CITY OF ALBUQUERQUE

October 30, 2017

Re: Murphy Express
1358 Wyoming Blvd NE
Traffic Circulation Layout
Engineer's Stamp 10-27-17 (J20-D037)

SHEET NO.
TCL-1

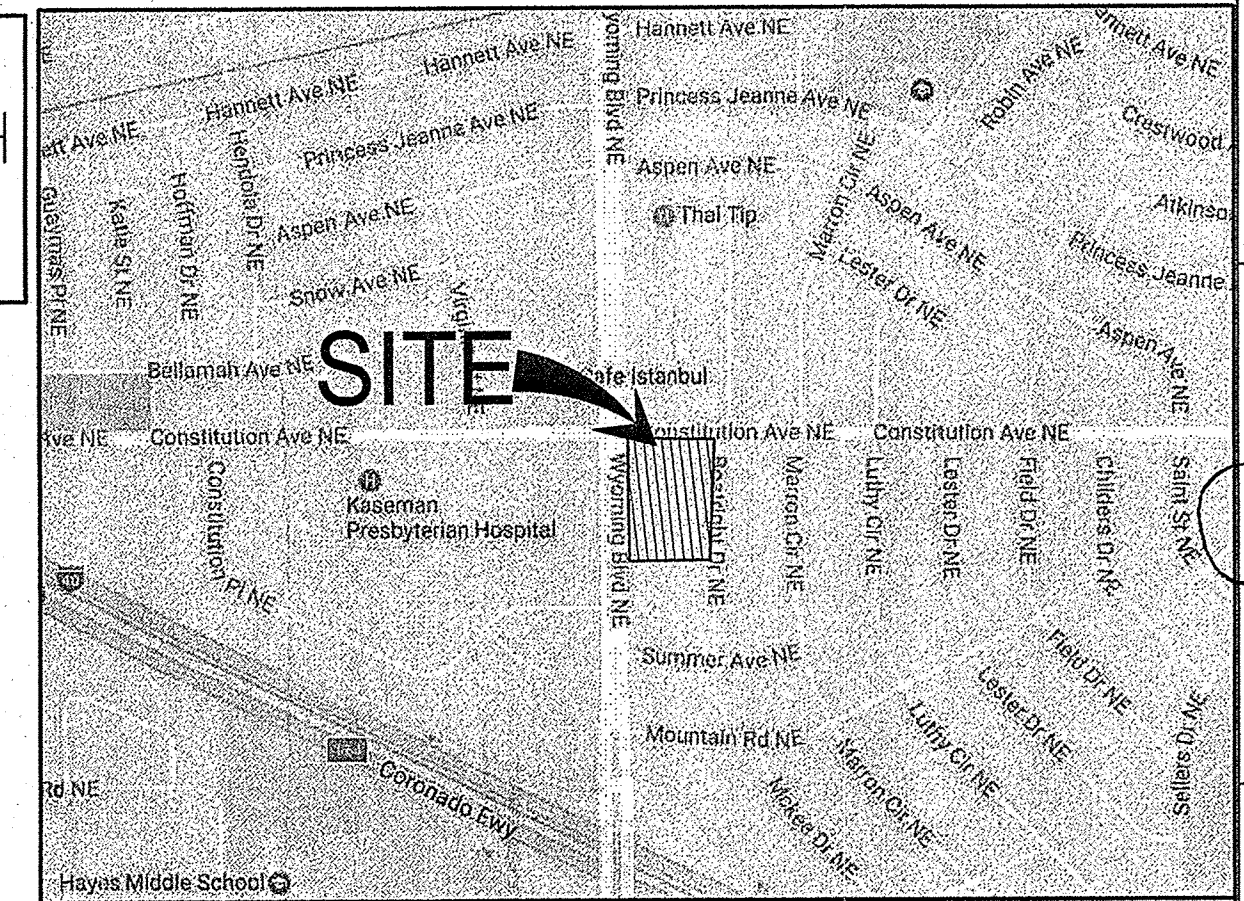
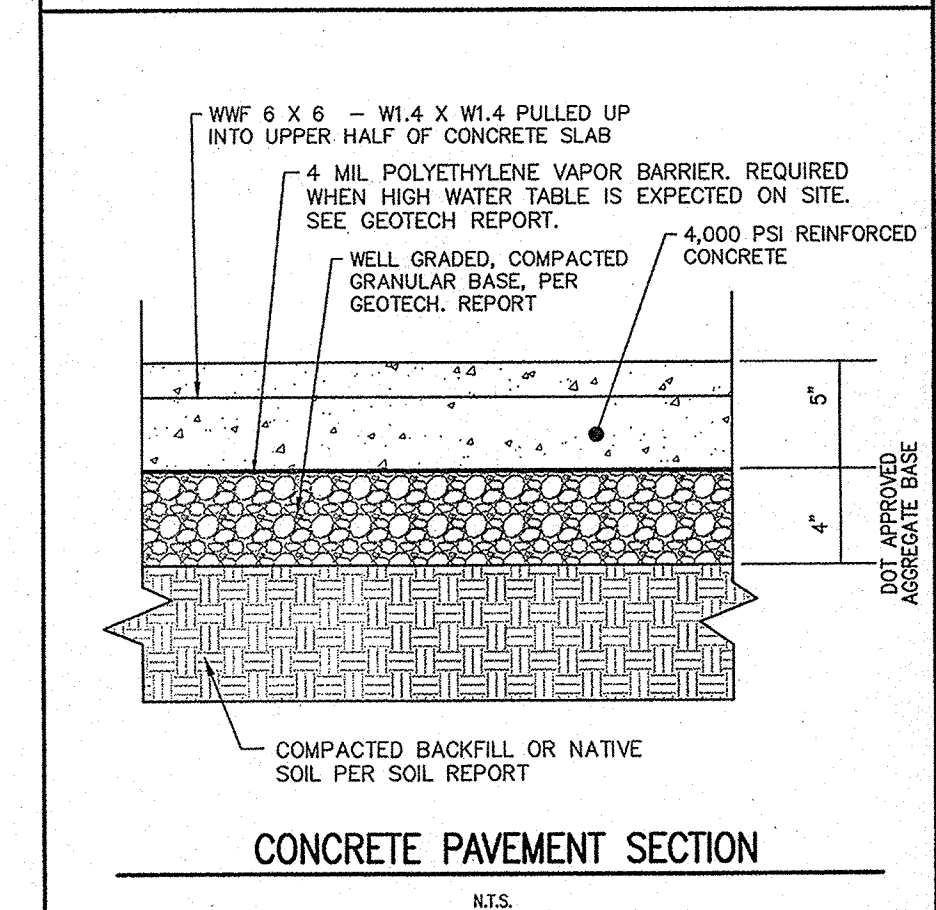
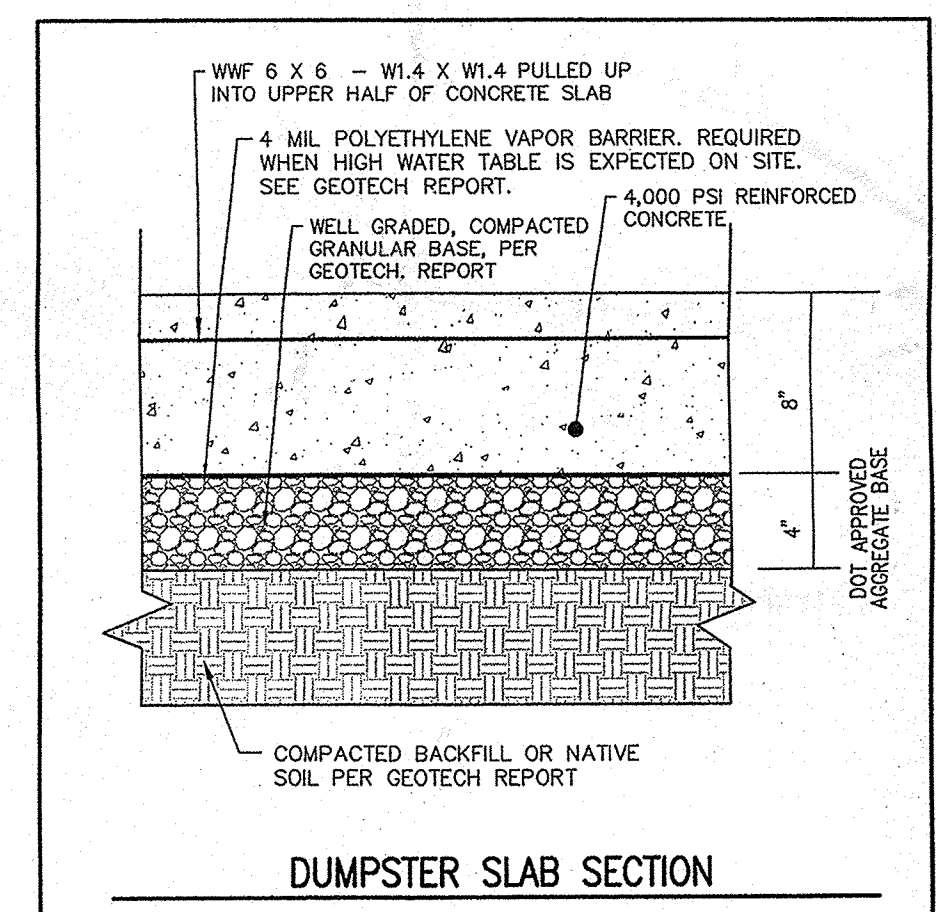
1. The no parking sign in the ADA access aisle may obstruct the ADA path. This sign is not needed.
2. ADA accessible pedestrian pathway should not be placed behind parking space or adjacent to a vehicular way. Vehicle and pedestrian/wheel chair conflicts should be avoided as much as possible. The pedestrian path next to the north entrance needs to be protected with curb or header wall.
3. Provide a min 6" or max 8" high concrete barrier curb or other acceptable barrier between landscaping and parking areas and/or drive aisles. Please call out detail and location of barrier curb. The parking next to the building should have parking bumpers. The plan refers to M3 on sheet C-12, but I am not seeing a M3.
